REQUEST

Current Zoning: R-4 (single family residential)
Proposed Zoning: R-12MF(CD) (multi-family residential, conditional)

Approximately 4.2 acres located on the south side of Lakeview Road, west of Reames Road, and east of Beatties Ford Road.

The petition proposes a residential community of up to 41 single family attached dwelling units on vacant land.

RZ.01

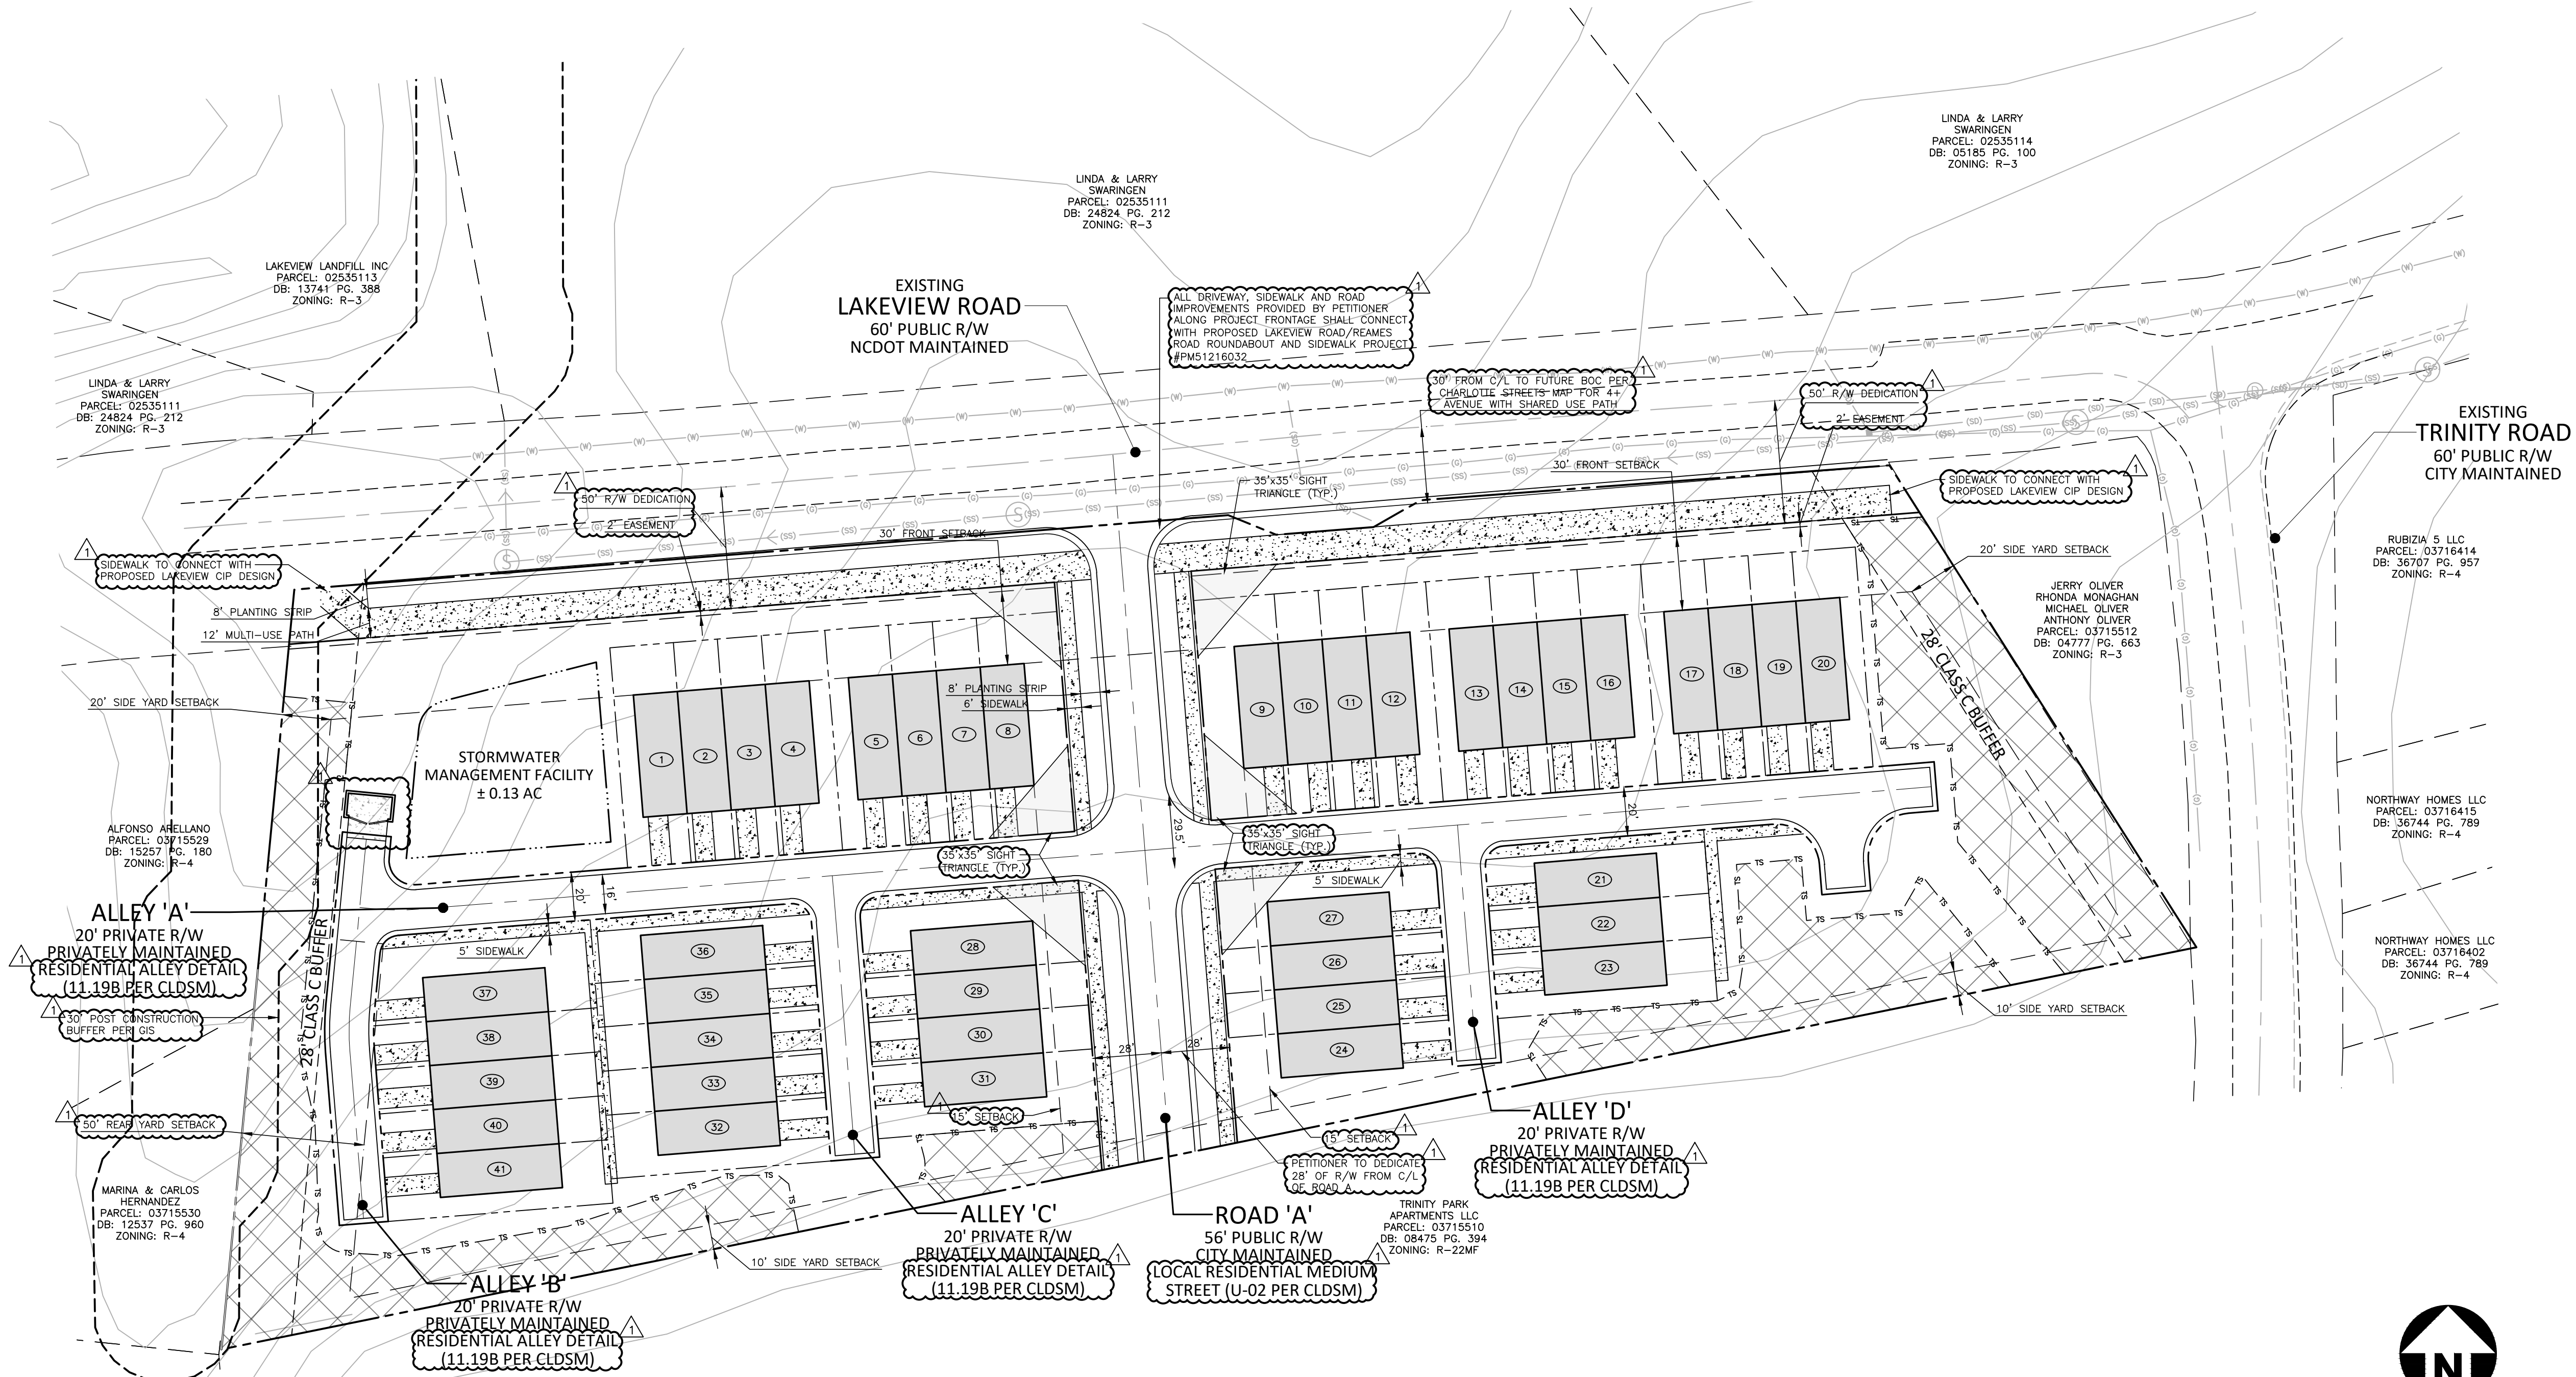
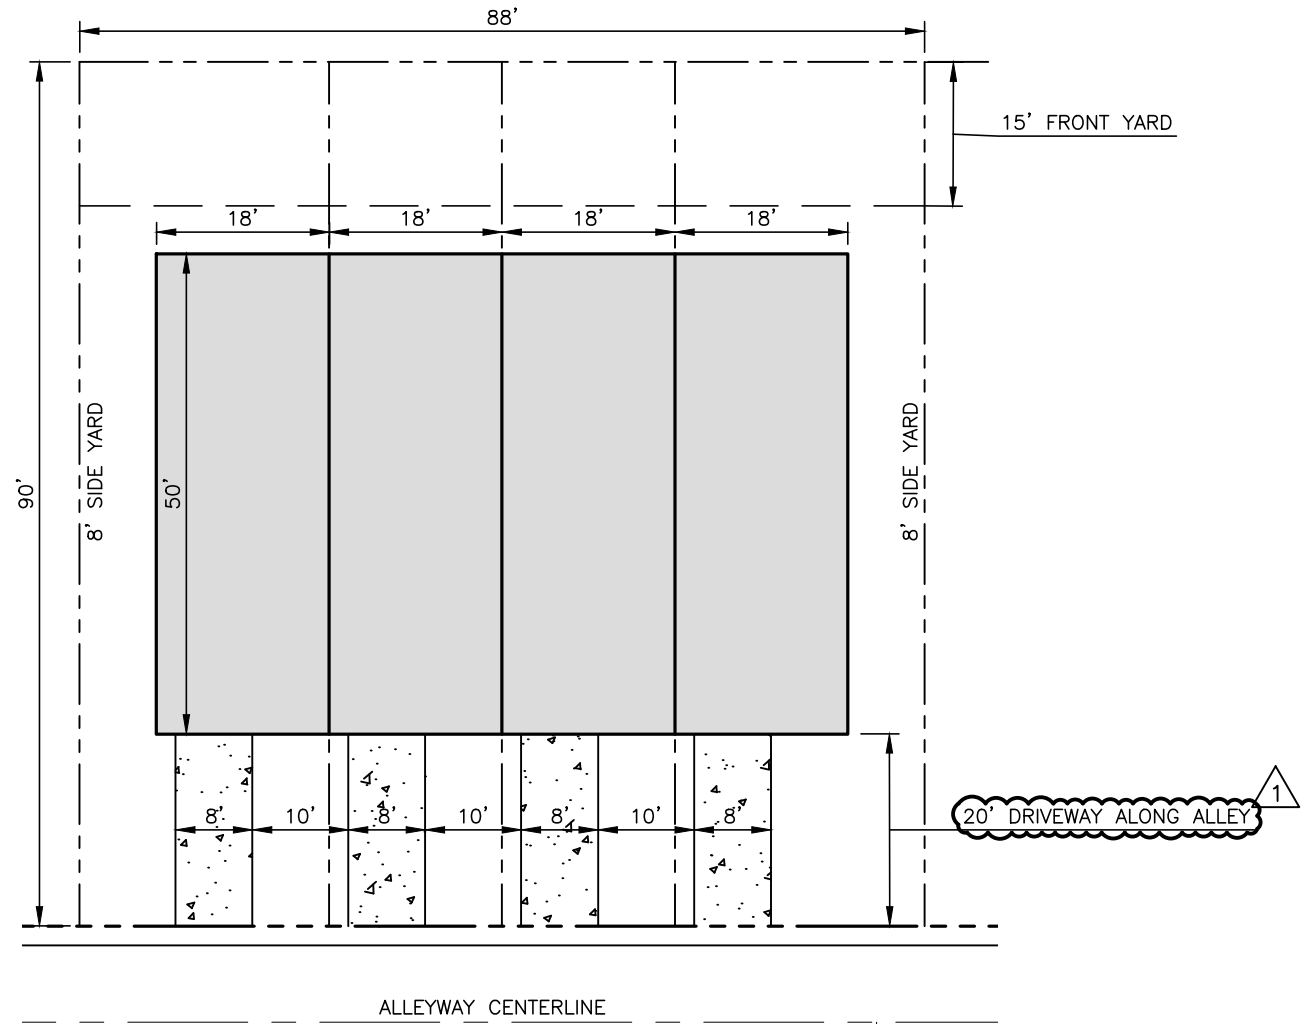
1. Add a conditional note specifying "A Right-of-Way Encroachment Agreement is required for the installation of any non-standard item(s) (irrigation systems, decorative concrete pavement, brick pavers, etc.) within a proposed/existing City-maintained street right-of-way by a private individual, group, business, or homeowner's/business association. An encroachment agreement must be approved by CDOT prior to construction/installation. Contact CDOT for additional information concerning cost, submittal, and liability insurance coverage requirements."
2. Driveways will be required to be moved out of sight triangles.
